Application Ref:	3/2026/0365			 Ribble Valley Borough Council www.ribblevalley.gov.uk	
Date Inspected:	N/A	Site Notice:	N/A		
Officer:	MC				
DELEGATED ITEM FILE REPORT:				Decision	REFUSAL

Development Description:	Prior notification for a proposed agricultural building for machinery and haylage under Part 6 Class A of the GDPO.
Site Address/Location:	Ease Barn Farm Gallows Lane Ribchester PR3 3XX

Drawing file: planx_downloads / 26_0365_OWNED_AND_TENANCY_PLOTS.pdf

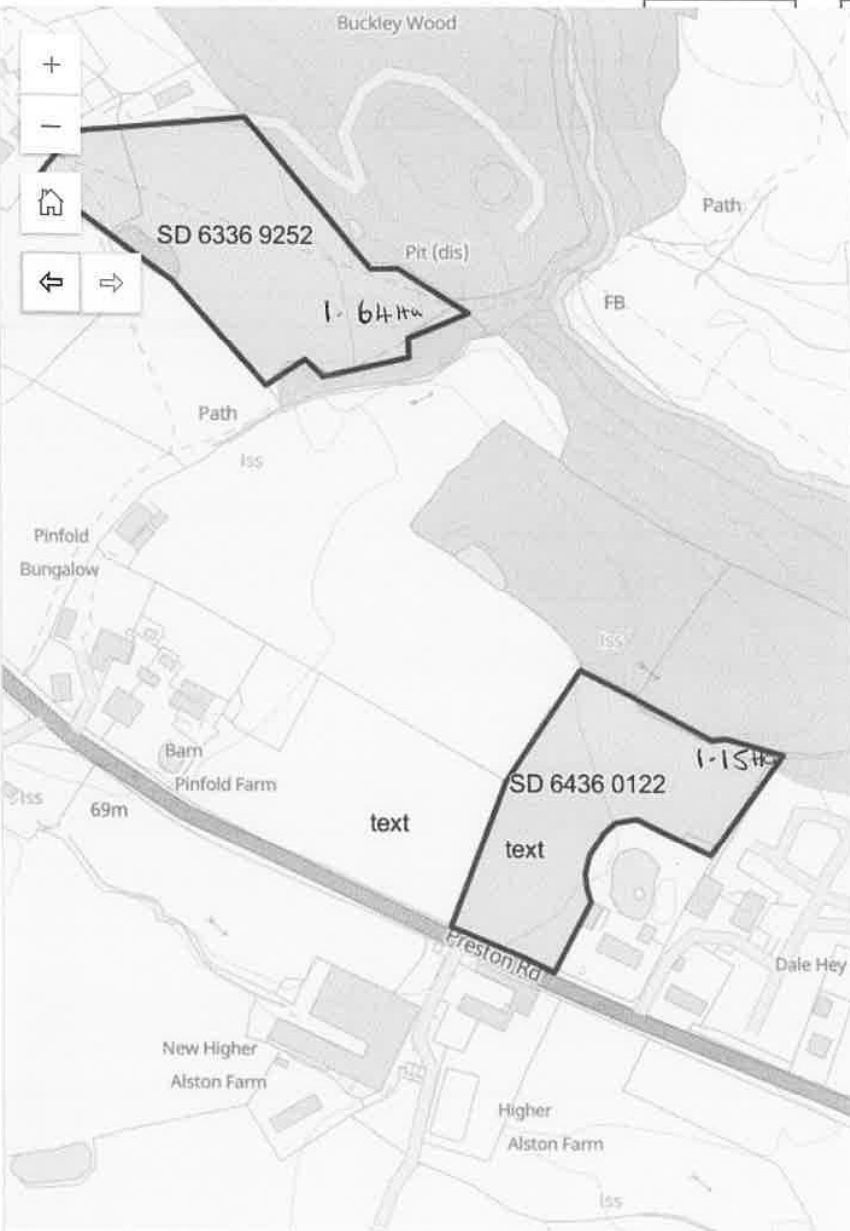
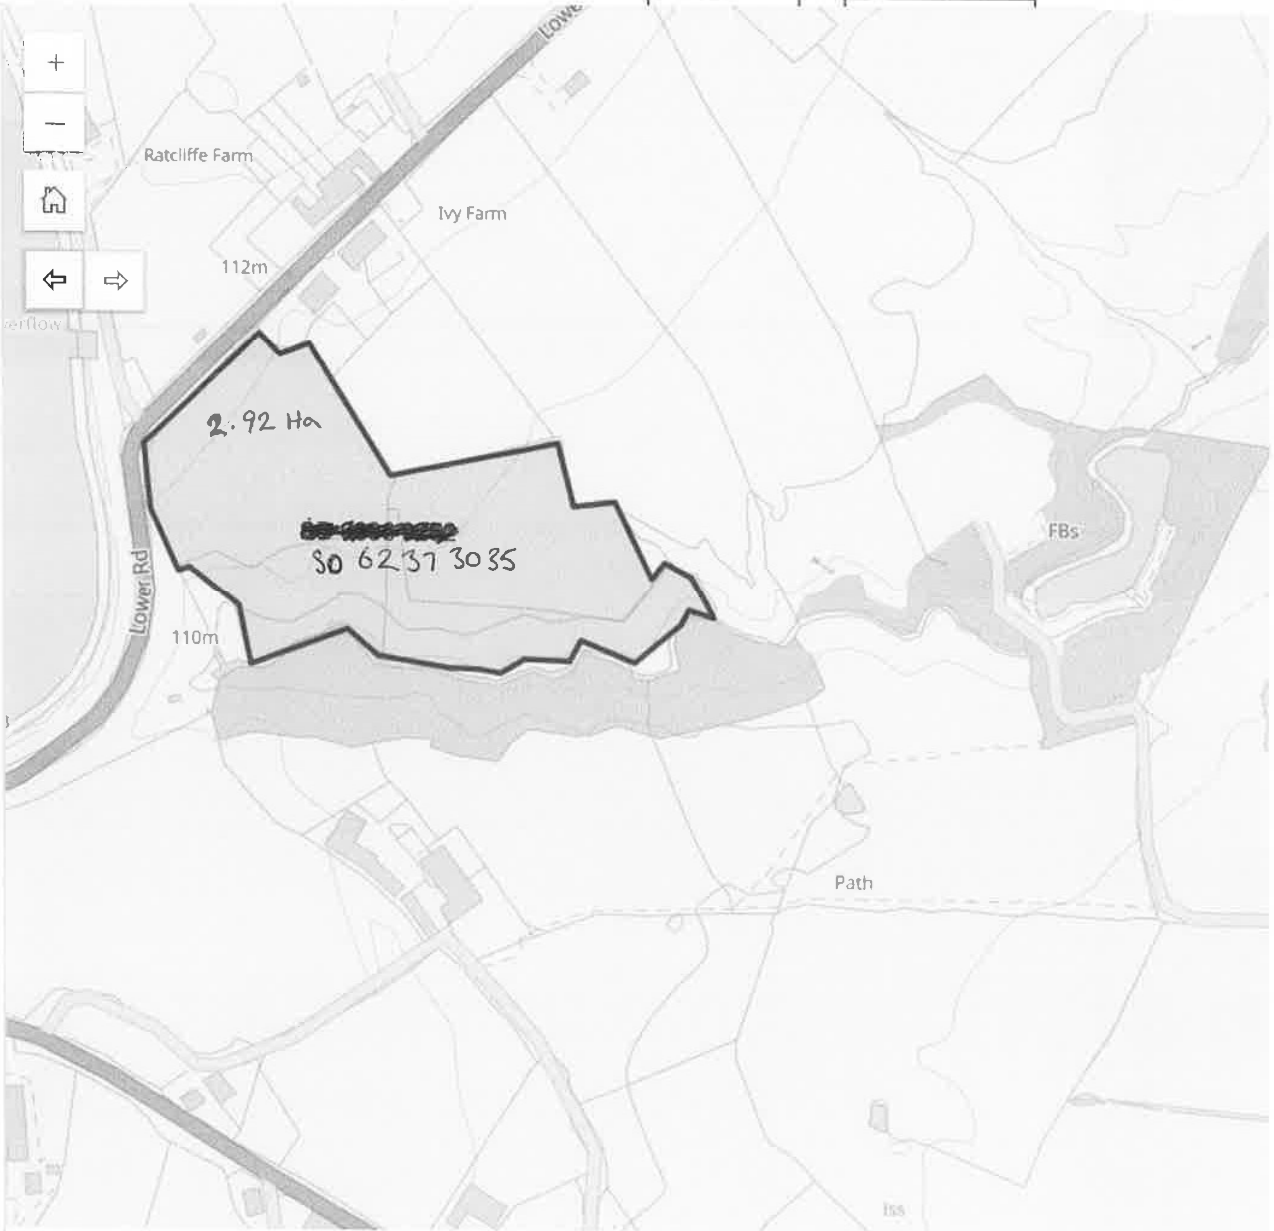
The submitted agricultural form indicates that the agricultural holding is approximately 8.82ha in size with 5.71ha being rented and 3.11 owned by the applicant. Whilst a plan has been provided identifying the land rented and owned by the applicant, the applicant has been unable to provide tenancy agreements for the rented agricultural land. In the absence of any evidence confirming an agreement exists on this rented land then cannot be included and the agricultural unit presented does not exceed 5ha.

Proposed Elevations &
Floor plan

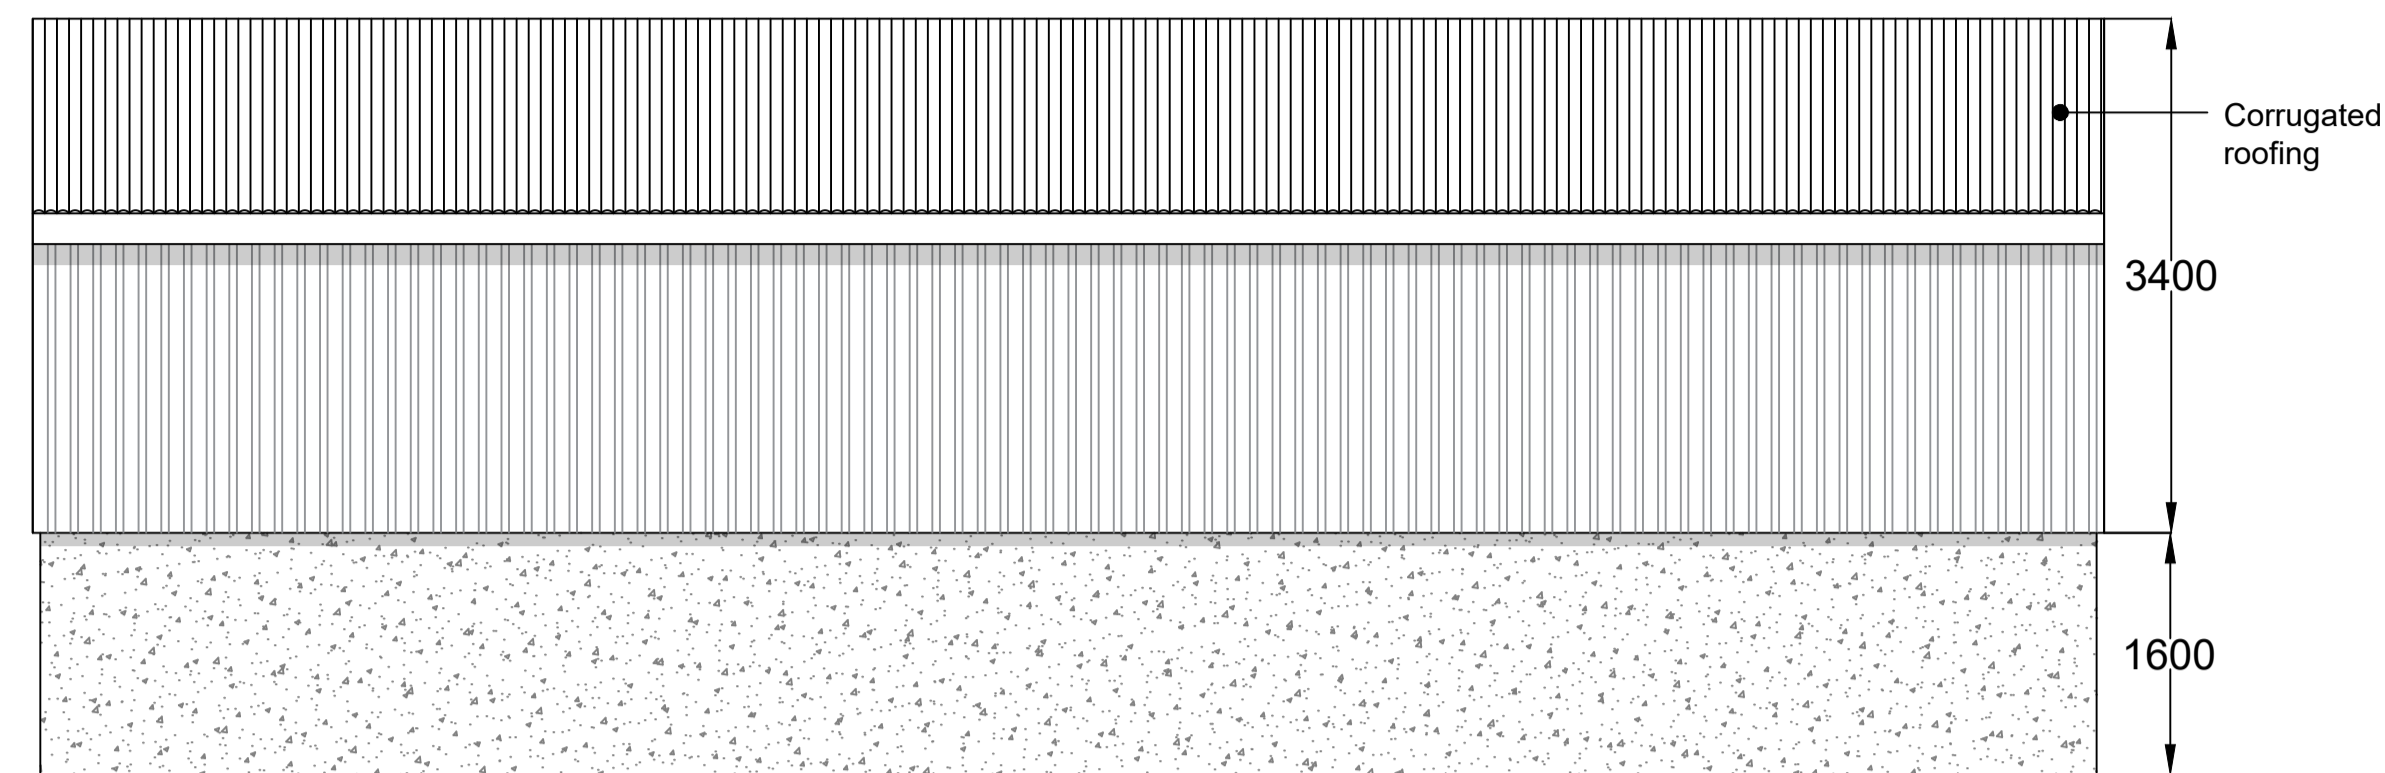
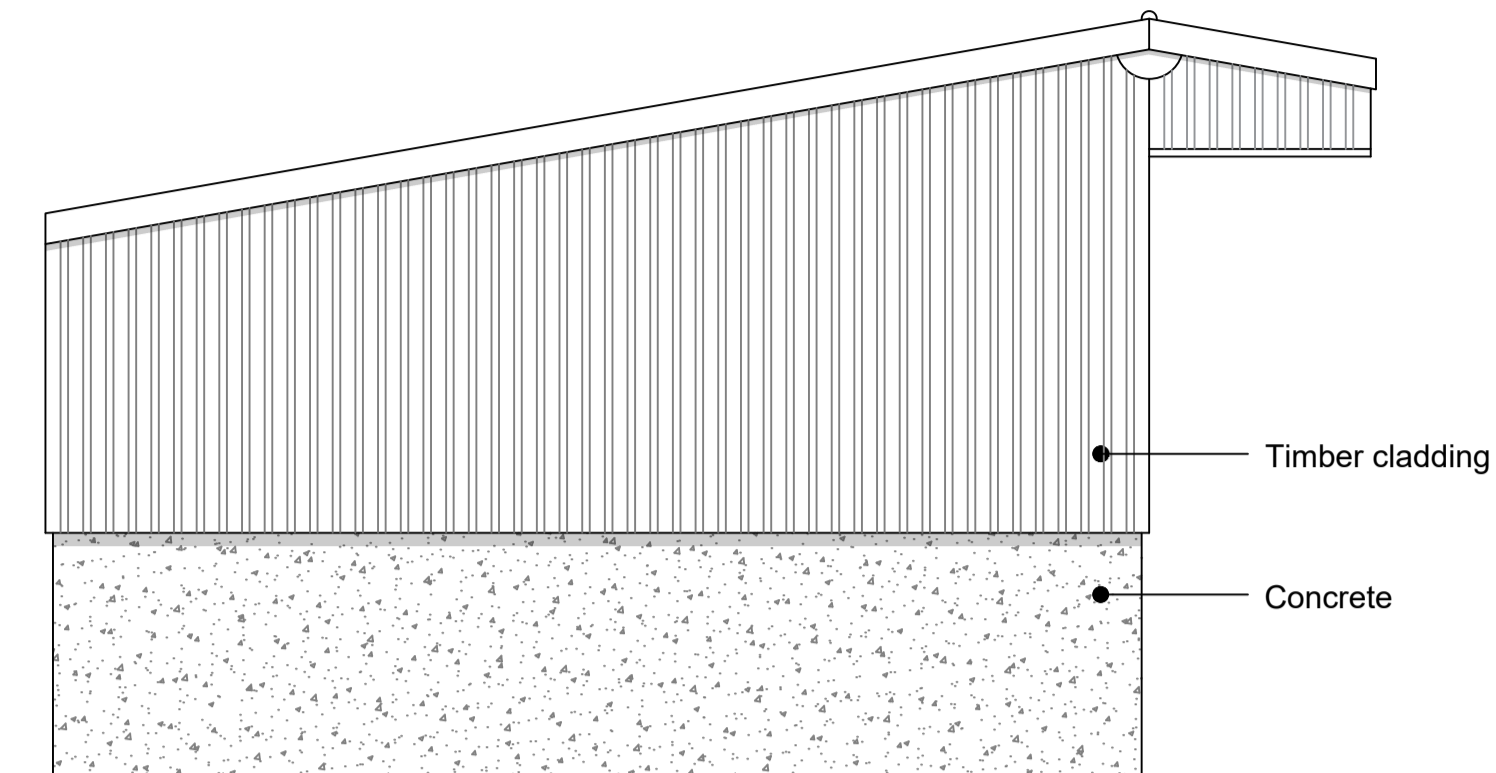
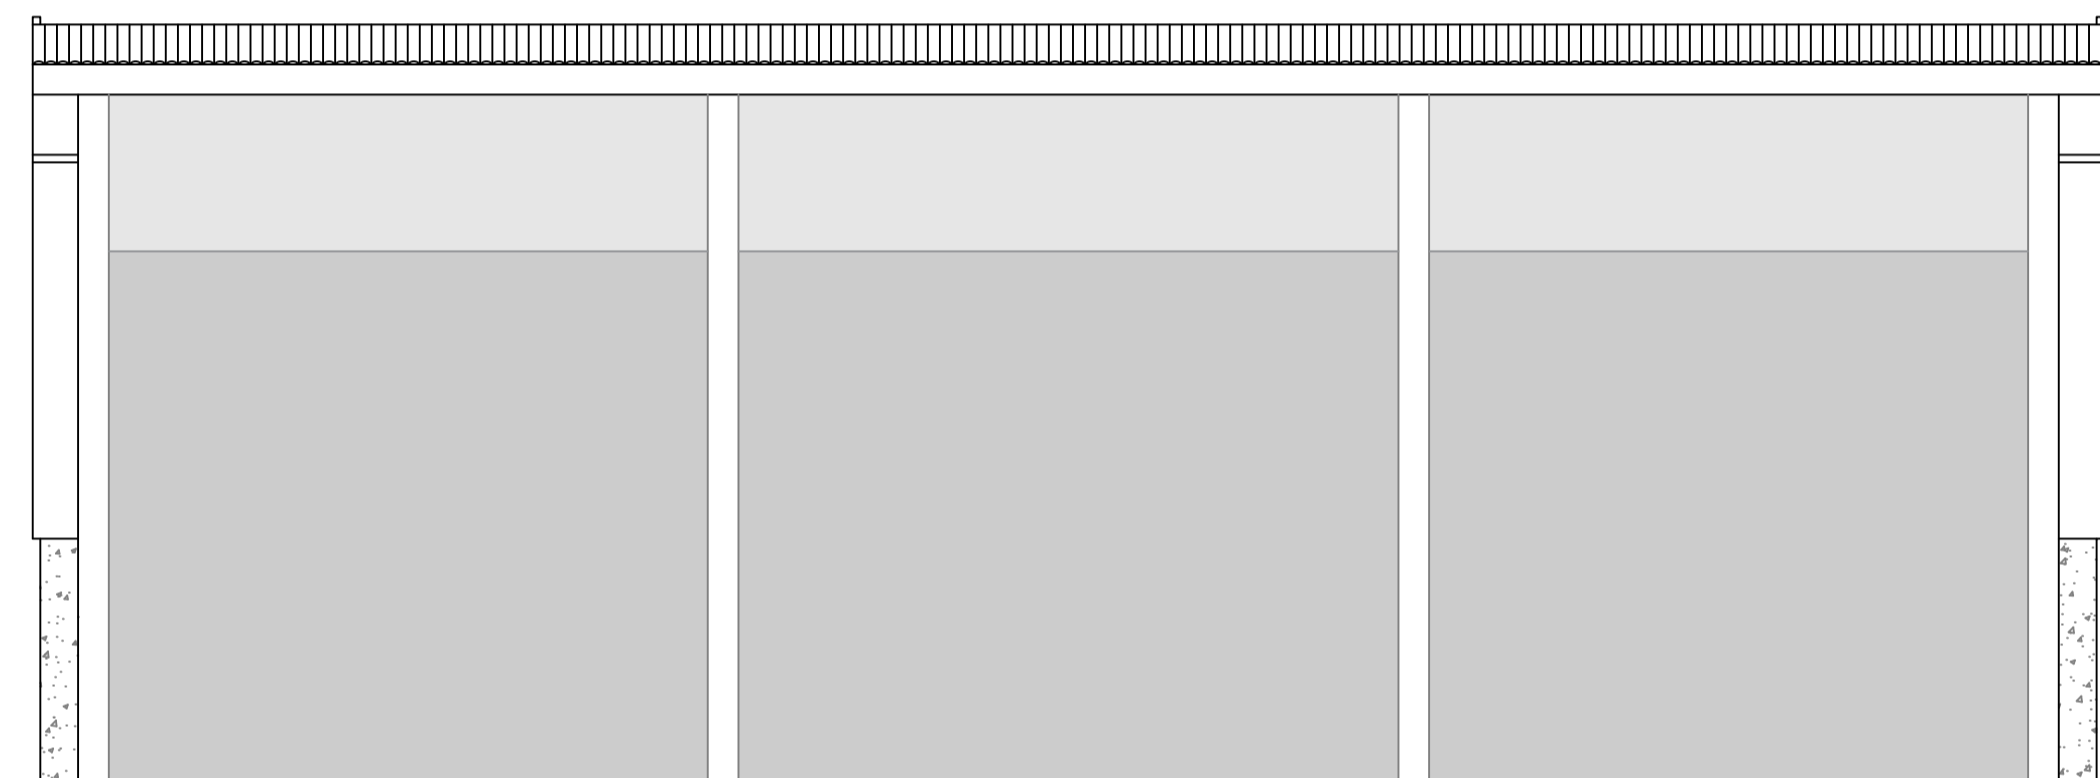
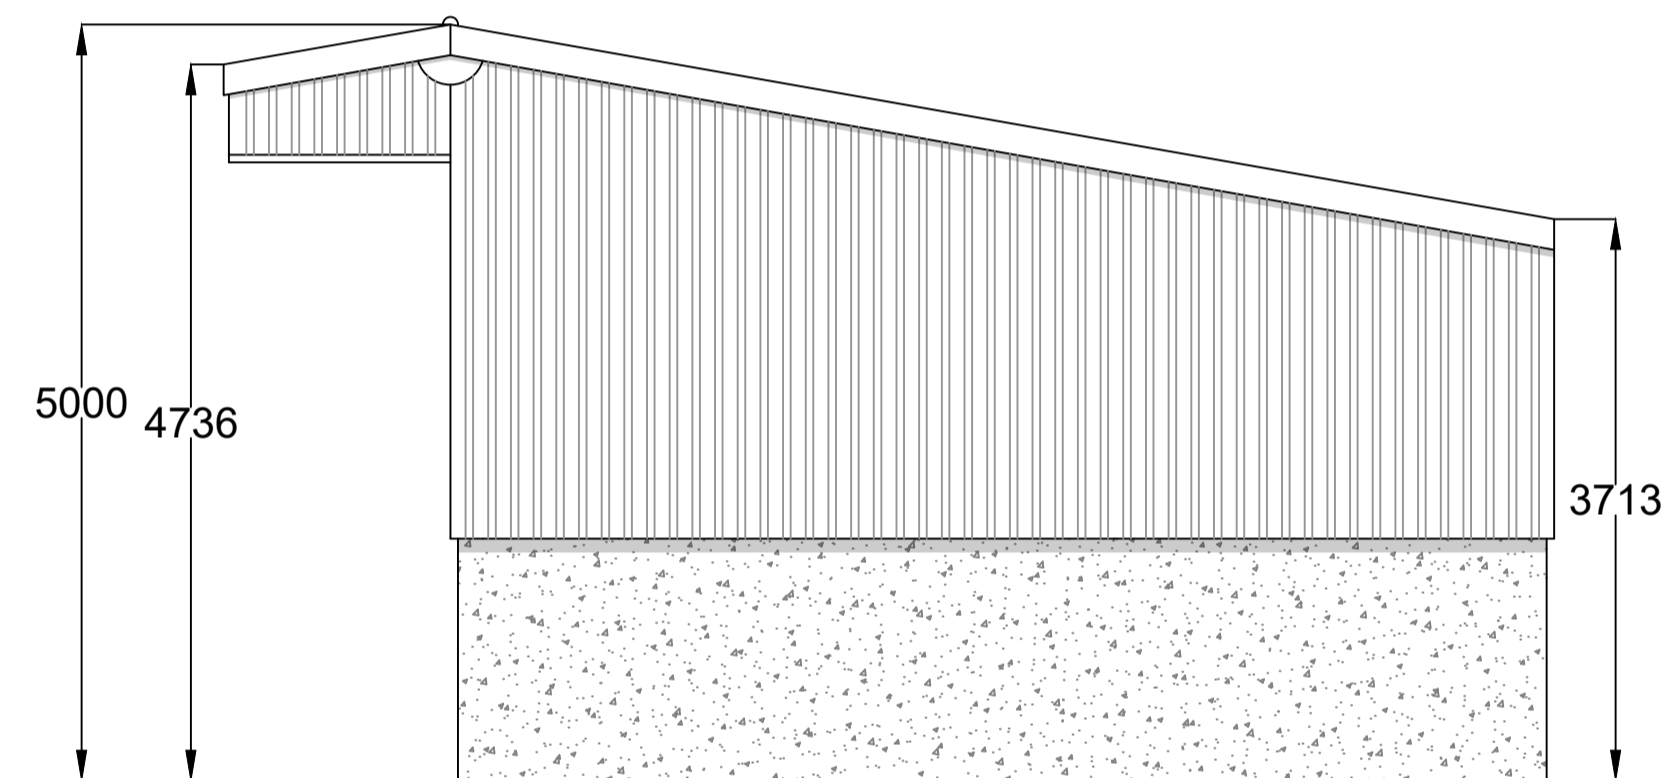
Siting – The proposed building is to be located on a parcel of land that lies adjacent to existing structures. The agricultural building would have a modest height at approximately 5 metres however, the building would be open sided to the north elevation which would help to reduce its visual massing. As such, it is

Design / appearance – The proposed building is to be constructed using a fibre cement roofing, with timber cladding to the upper part of the gable and concrete panelling to the perimeter of the building. As such, the appearance of the building would be appropriate in terms of its design and materials for agricultural storage.
